TfNSW reference: STH19/00029/09

Your reference: SSI-10033

SSI-10033 – Environmental Impact Assessment- Shoalhaven Hydro Expansion Main Works

Figure B-1 Indicative intersection upgrade layout

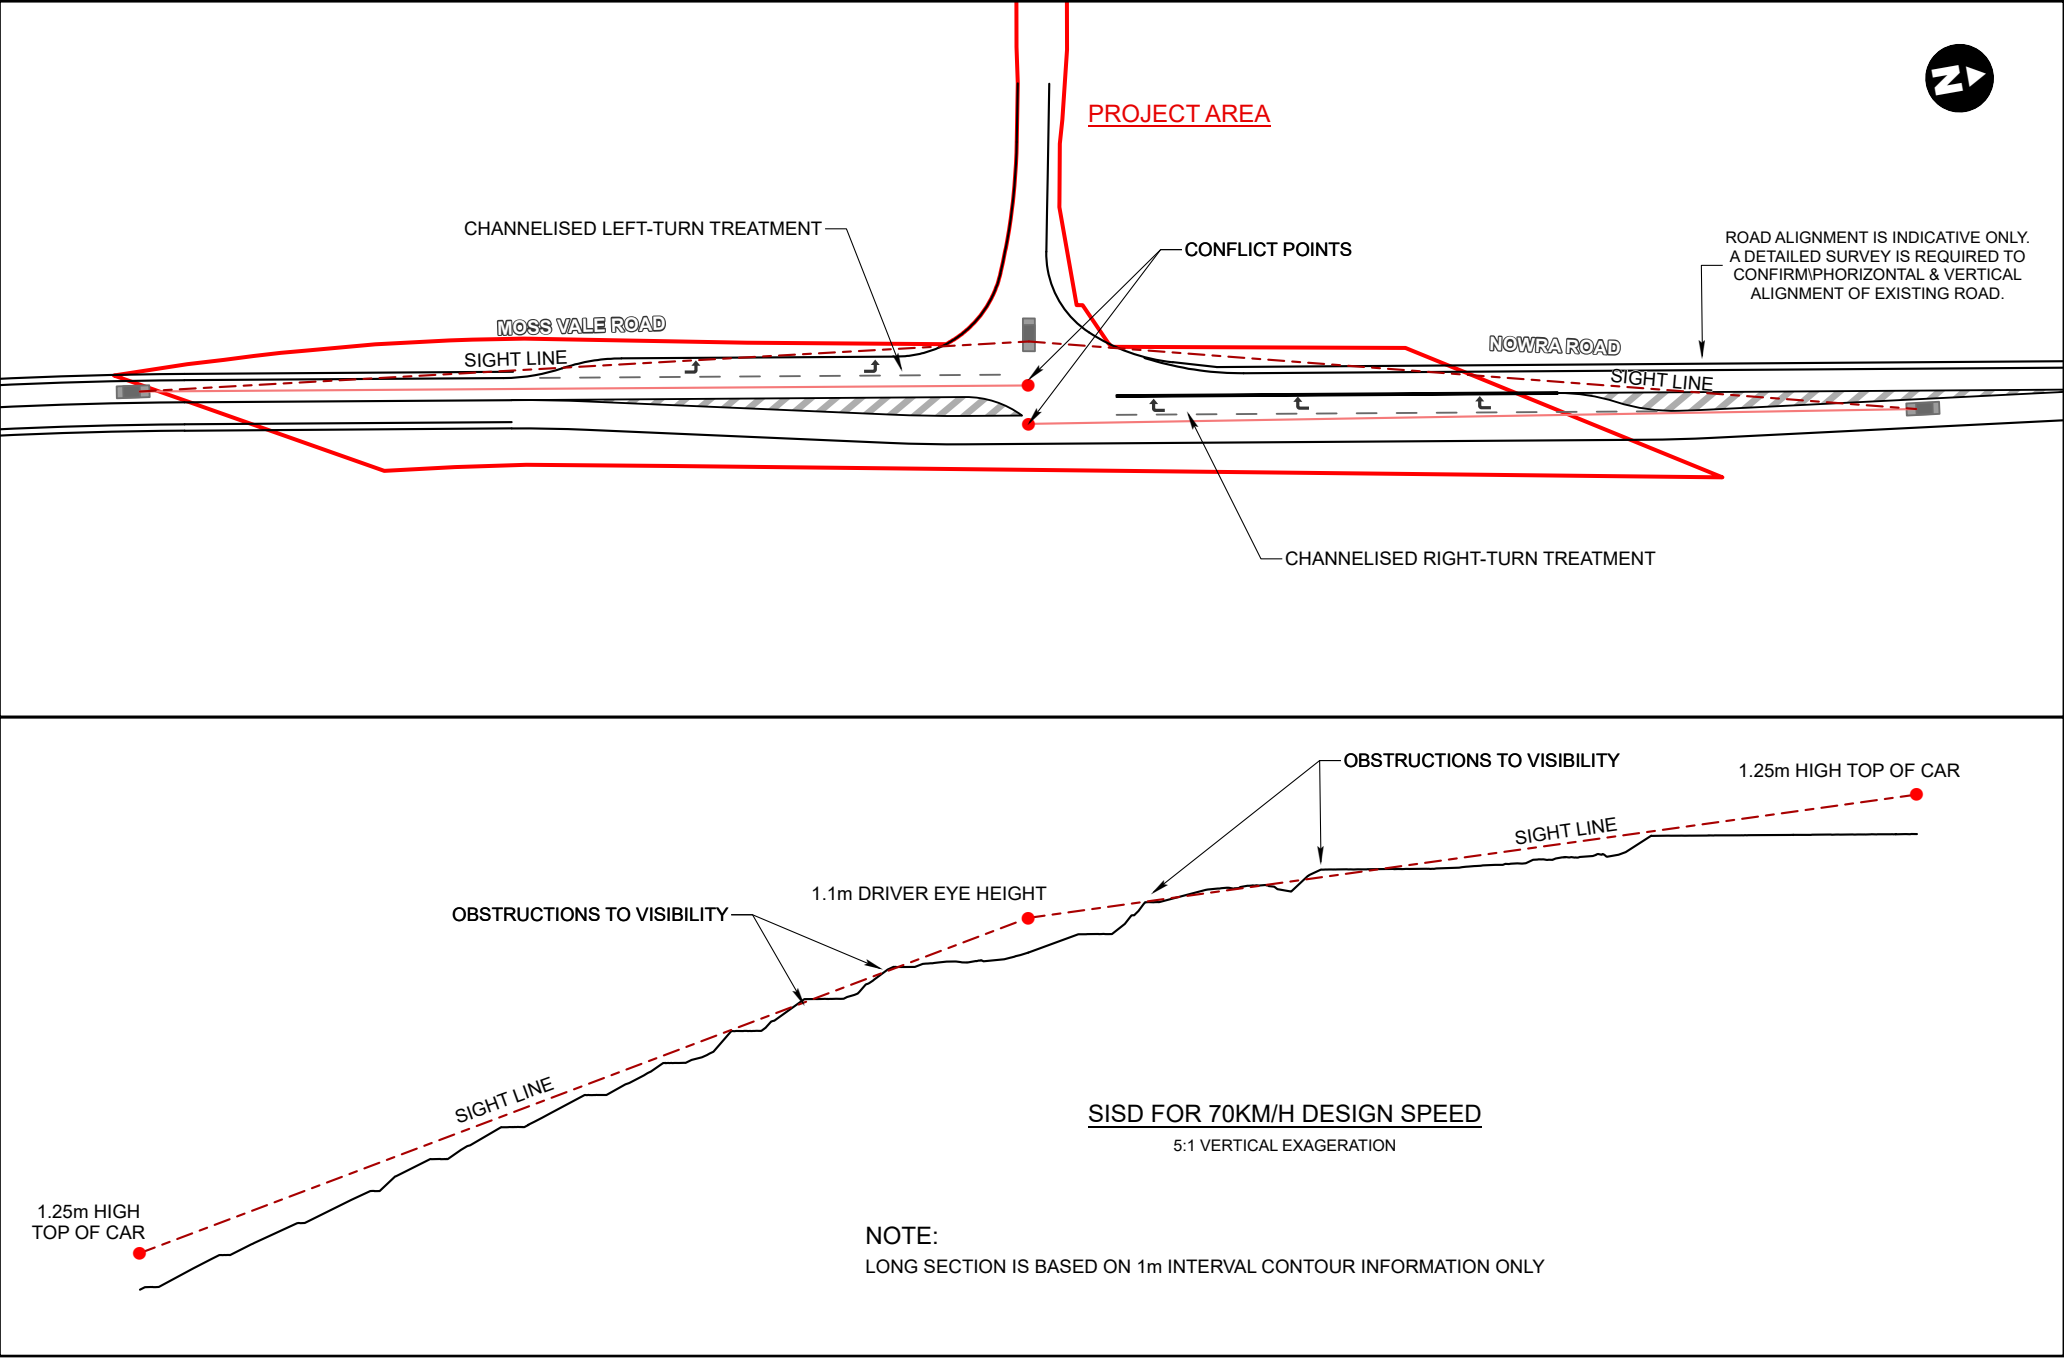
TfNSW acknowledge that a potential upgrade is proposed in Appendix B of the EIA, however the plan is indicative and therefore assessment cannot be made with this level of detail.

- i. A strategic design is required, to determine the environmental impacts of the intersection treatment and allow TfNSW to review the proposal. The plan should be based off survey, with scaled details showing lengths of auxiliary lanes, storage, taper lengths, radii used, cadastre, utilities etc.

- ii. The report states that all sight distance checks are preliminary, and a check required prior to construction. Key sight distance checks and analysis needs to be performed prior to approval. This includes ASD, SSD to ensure proposal is in the safest possible location.

- iii. SISD checks should be 1.1m through traffic eye height to turning car at 1.25m. See AGTRD Part 4A Unsignalised and Signalised Intersections Figure 3.2.

- iv. The turn warrant assessment should be updated for the Nowra Road/Promised Land Trail. Currently the posted speed limit is 100km/h and TfNSW have no plans for reduction of the speed limit to ≤ 70 km/h. Using the correct figure, it indicates a higher order turn treatment is warranted and required. TfNSW note that a turning treatment is proposed within the EIA.

- v. A swept path assessment of the design vehicle needs to be undertaken for all movements proposed at the intersection. Any larger check vehicle should also be undertaken.

- vi. The length of storage for turn lanes should be adequate to store the largest heavy vehicle utilising the access under normal traffic conditions.
